March 26, 2024

**SUBJECT: Struthers Ranch Polaris  
Detention Basin Certification Letter**

WATER QUALITY POND A  
PLAN & DETAILS

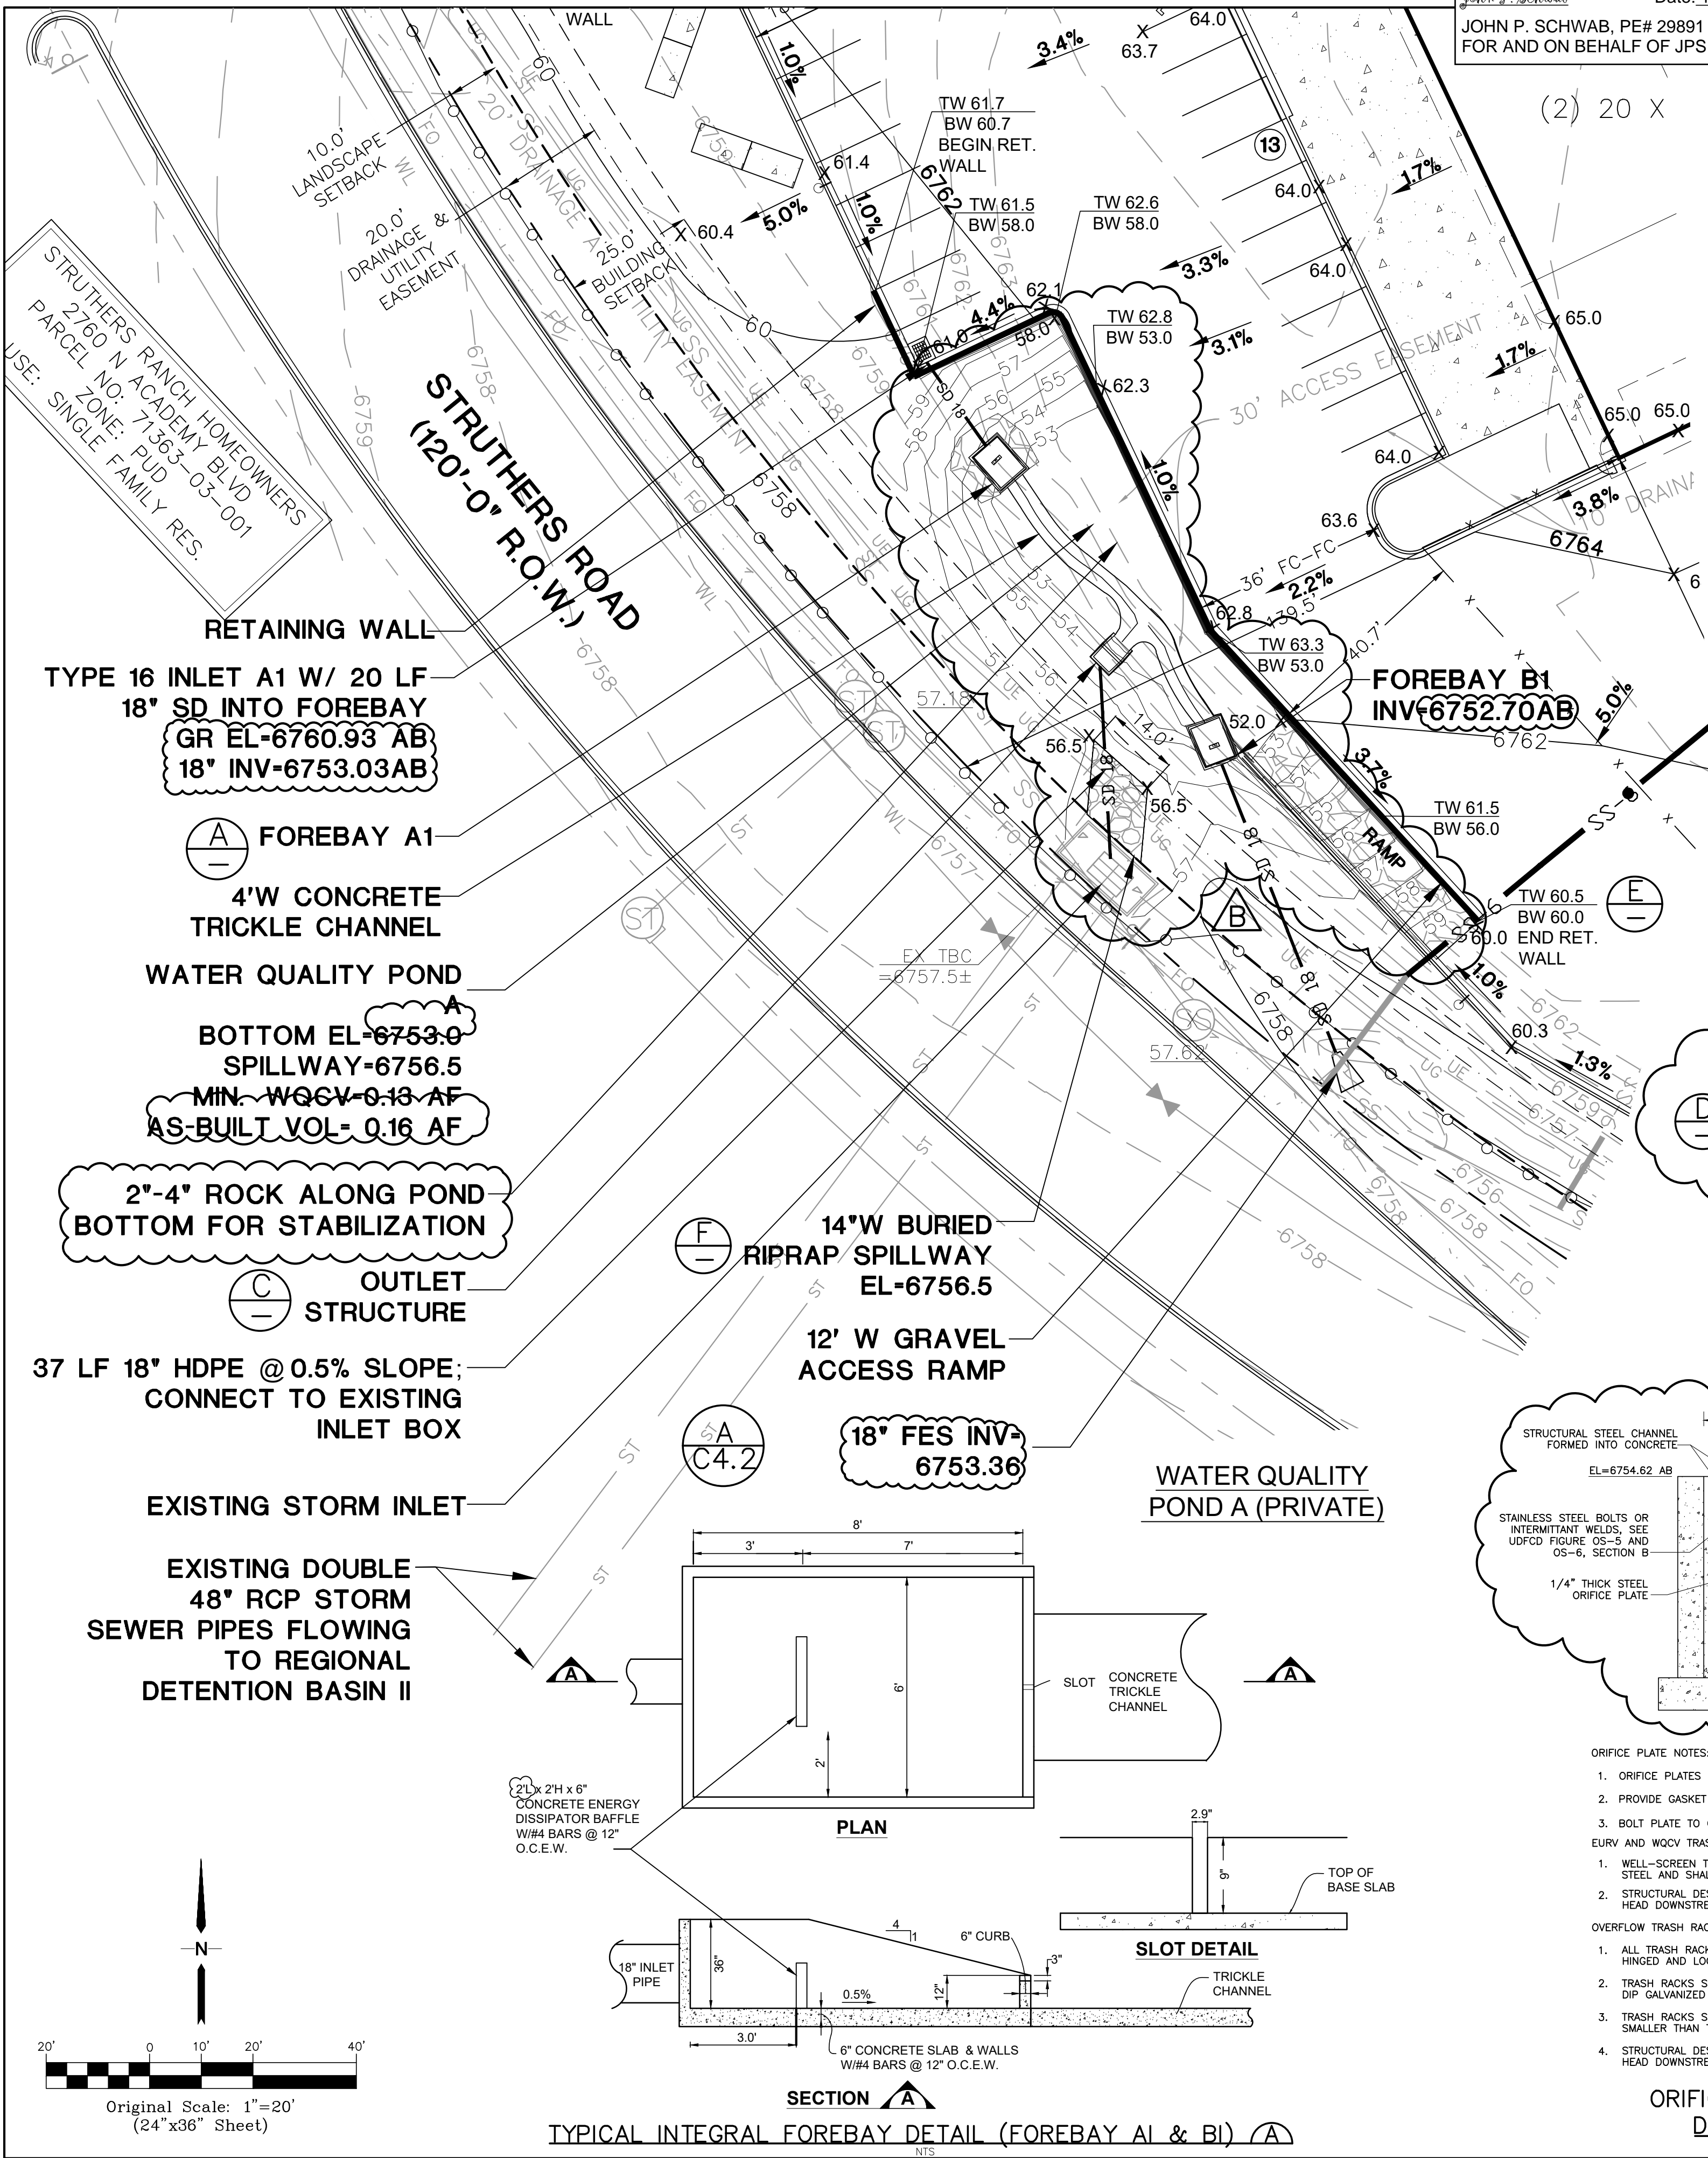
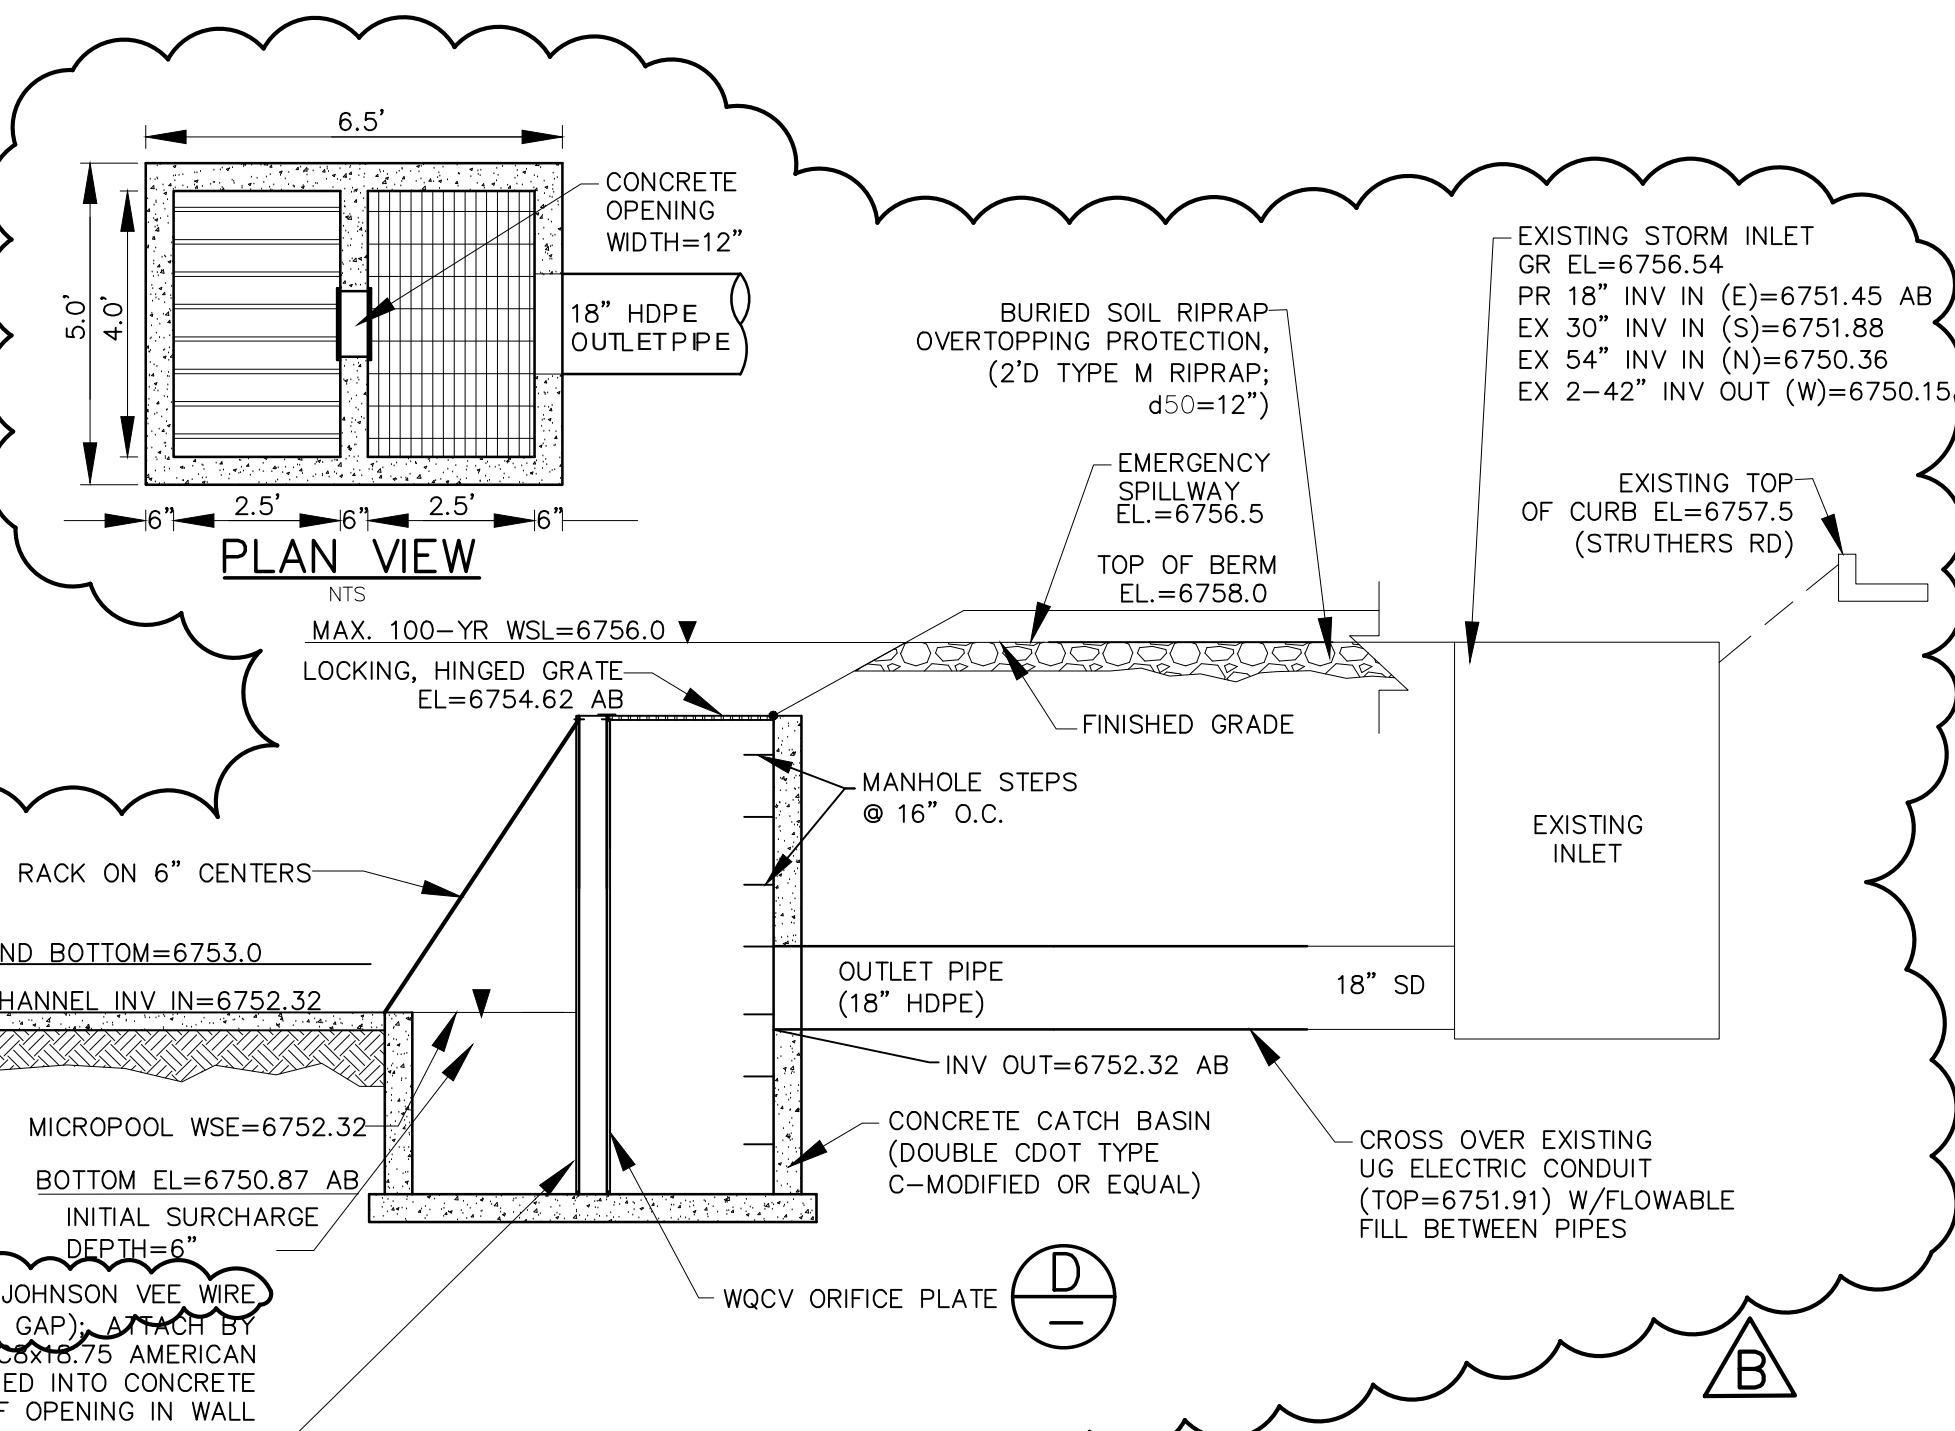
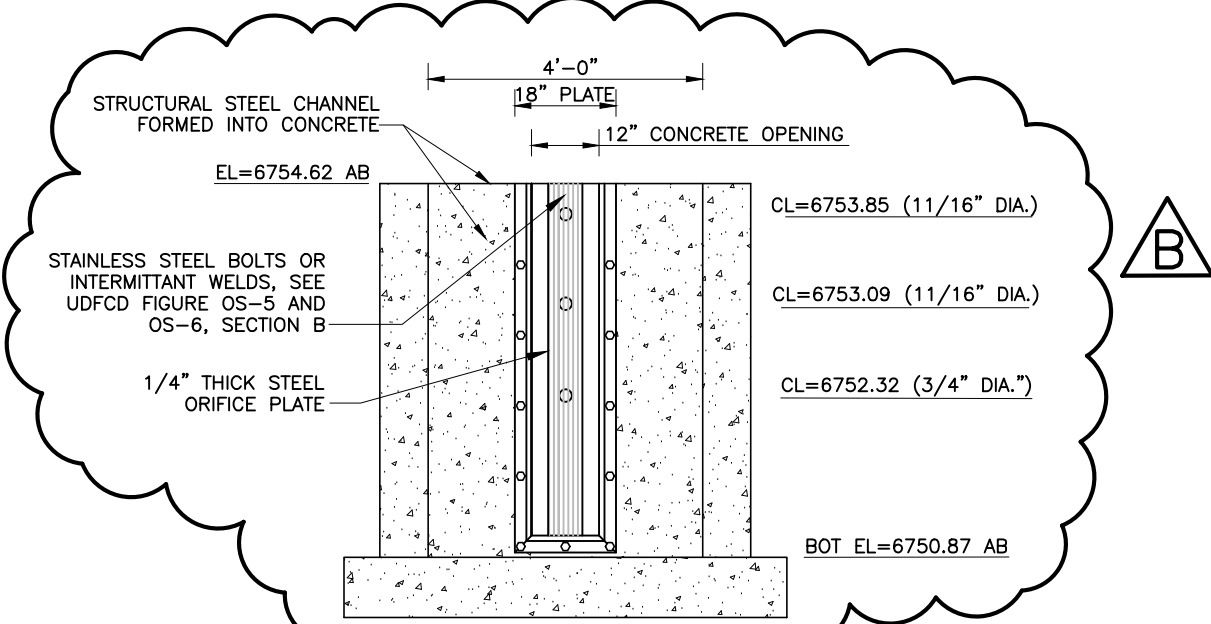
If there ends up being changes to any of the MHFD-Detention inputs from original design to as-built condition (like the Inv of the outfall pipe, for example):

Please have the engineer update the MHFD-Detention Spreadsheet with the updated as-built information (pond elevations, spillway length, orifice hole elevations, etc.) to confirm that the pond is functioning as intended. The original Spreadsheet is included with the approved Drainage Memo. The updated Spreadsheet should be attached to the Pond Certification Letter.

For sites including detention and/or water quality facilities, the certification letter shall include a statement that the facilities provide the required storage volume and will meet the required release rates (as documented by an attached MHFD design form submitted with the original application), the stage areas, elevations, and outlet dimensions.
